Fontwell Avenue,
Eastergate,
West Sussex.
PO203RU
30.07.18

We wish to object to planning application AL/67/18 PL which requests variance of Condition 6 imposed on planning application AL/122/17/PL. This is to allow the applicant to begin building his houses before the access and internal road are completed. We do so for the reasons listed below:-

PROPOSED SITE PLAN 1:500

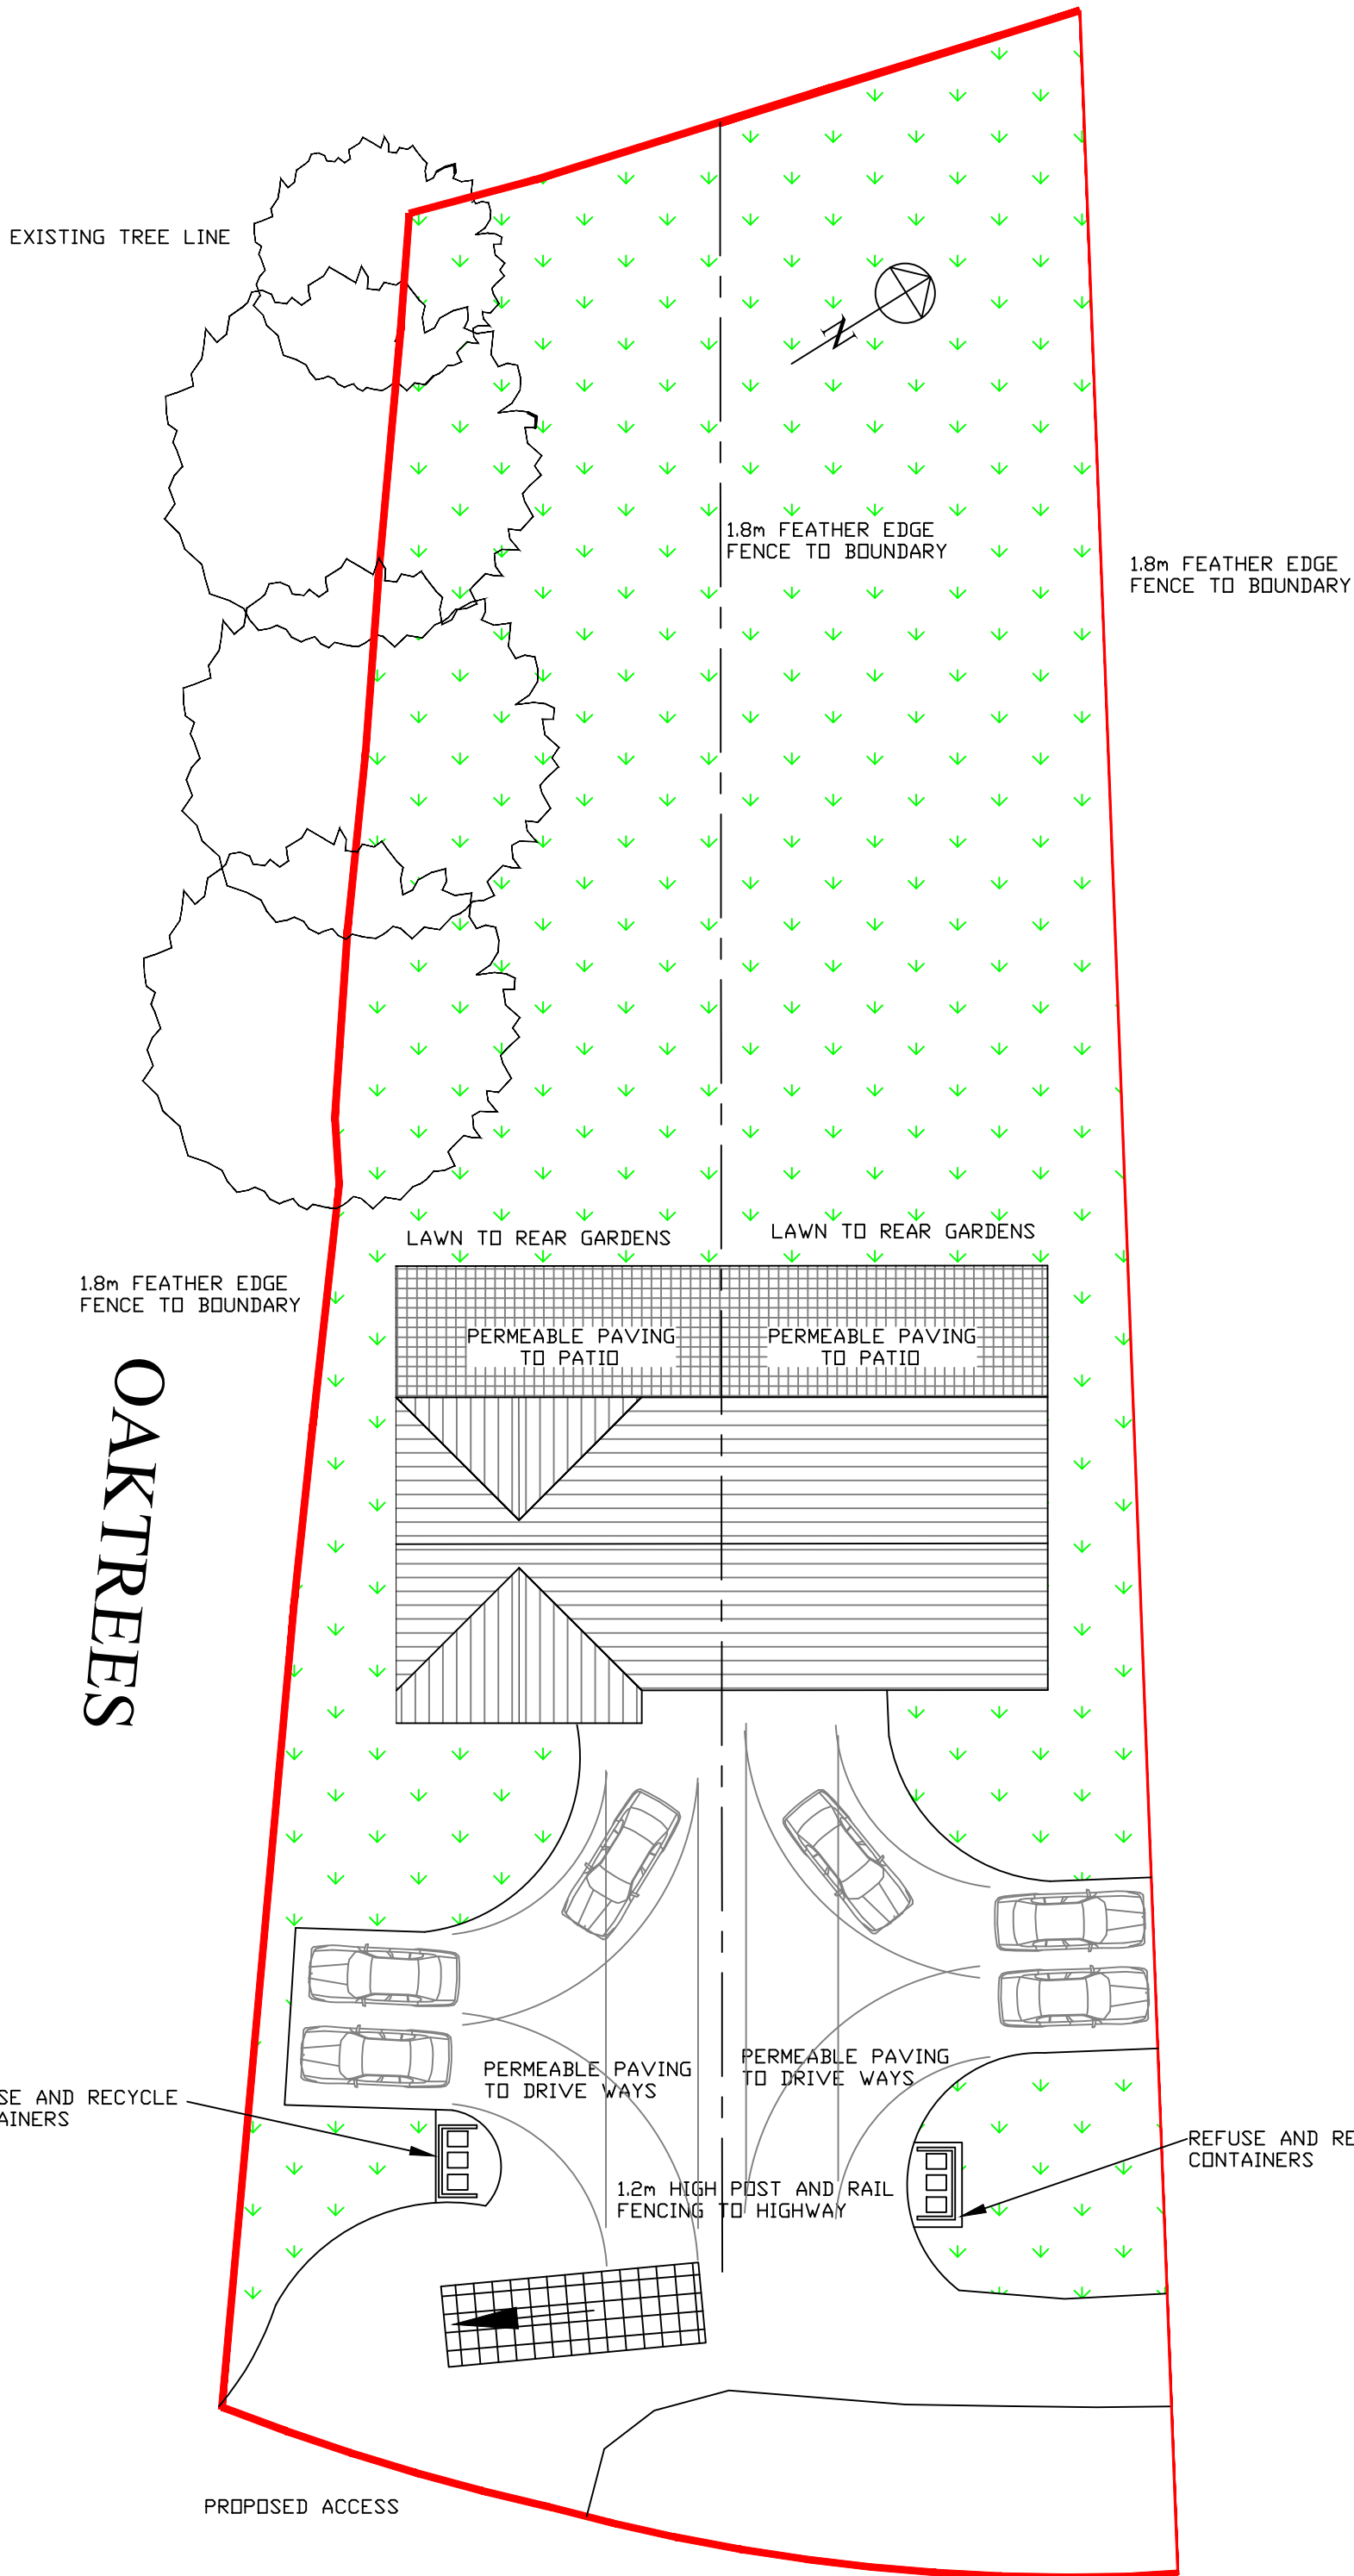
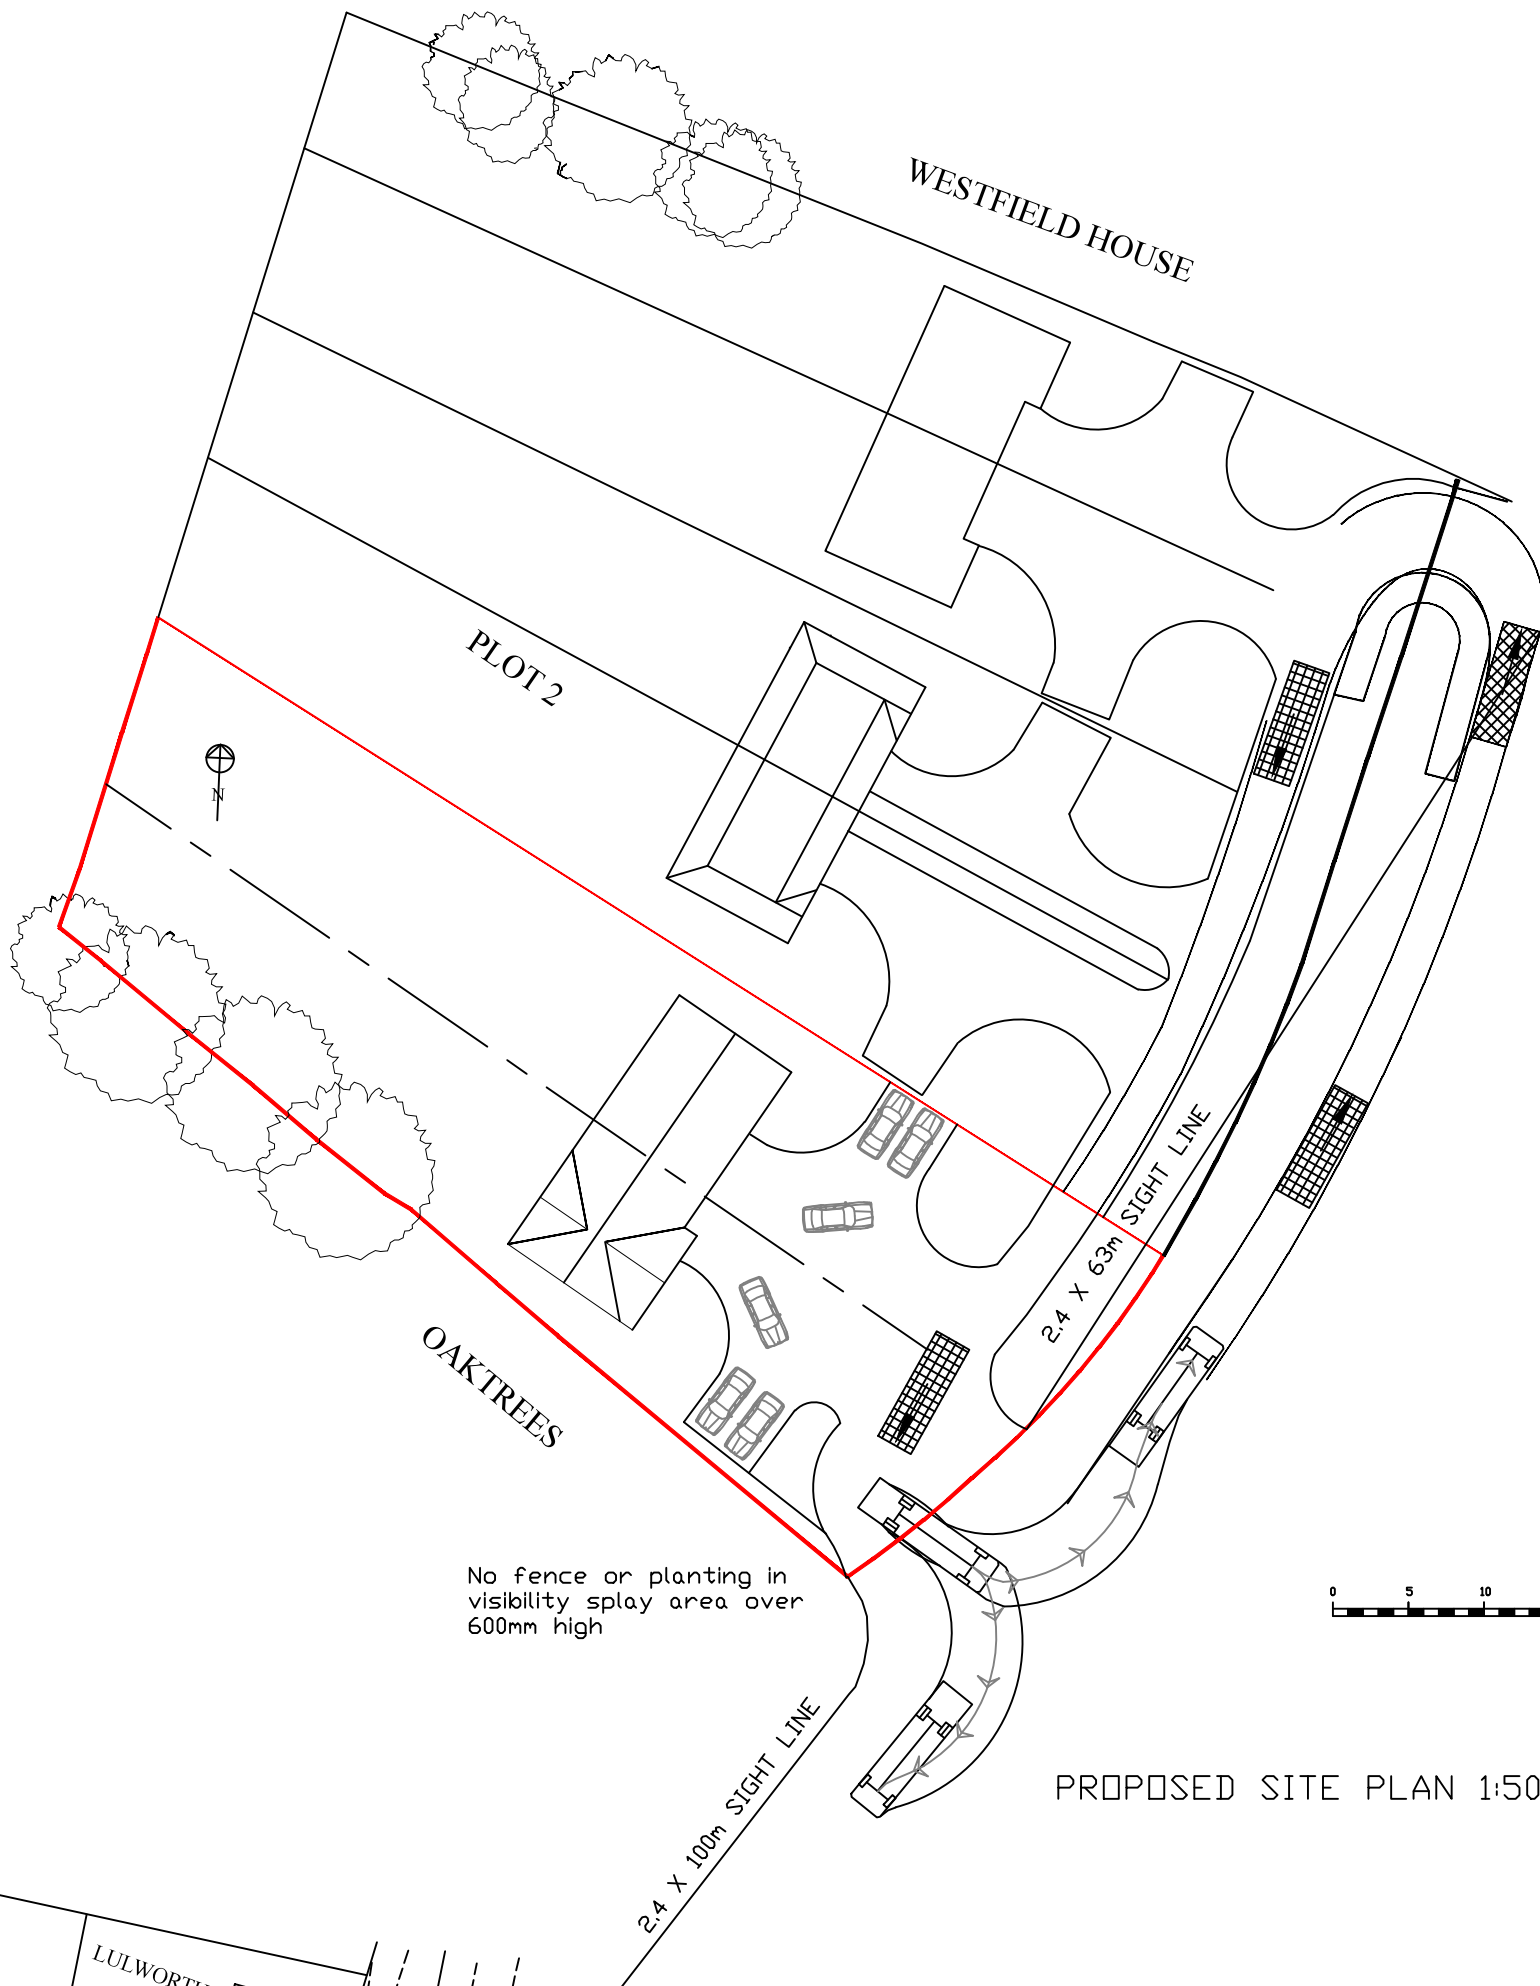
2. The owners of the northern most section of land have already changed the access agreed by previous planning permissions, as it is much wider than the one shown on the plan. They have in fact created a layby on the A29. The internal road has also been cut off at the edge of the first section of ownership, making a small open parking area. Consequently, many lost H.G.V. vehicles travelling on the A29, pull into the access (parking across ours), when they are unable to find the address they are looking for or pull into the parking area and then have to reverse out again against the oncoming traffic. This difficulty has increased since construction

5. The actual road within the site and the 'parking area' which Mr. Norton has started to build has been constructed in the wrong place on the land. A buffer/landscape feature, has been omitted and for part of the site, the road runs adjacent to the boundary, instead of about 3m away from it. Mrs. Dannatt has already made a site visit and observed this. Also, the road has also not been constructed with the materials specified on the planning documents. Instead, Mr. Norgate has brought in large pieces of demolition waste. You have photographs to show this and it is present and visible on the site. Other people have also brought their demolition waste to the site which could even be hazardous. Additional photos of questionable waste being tipped are available. **Mr. Norgate has shown that he does not comply with planning arrangements which already exist and they should not therefore be varied.**
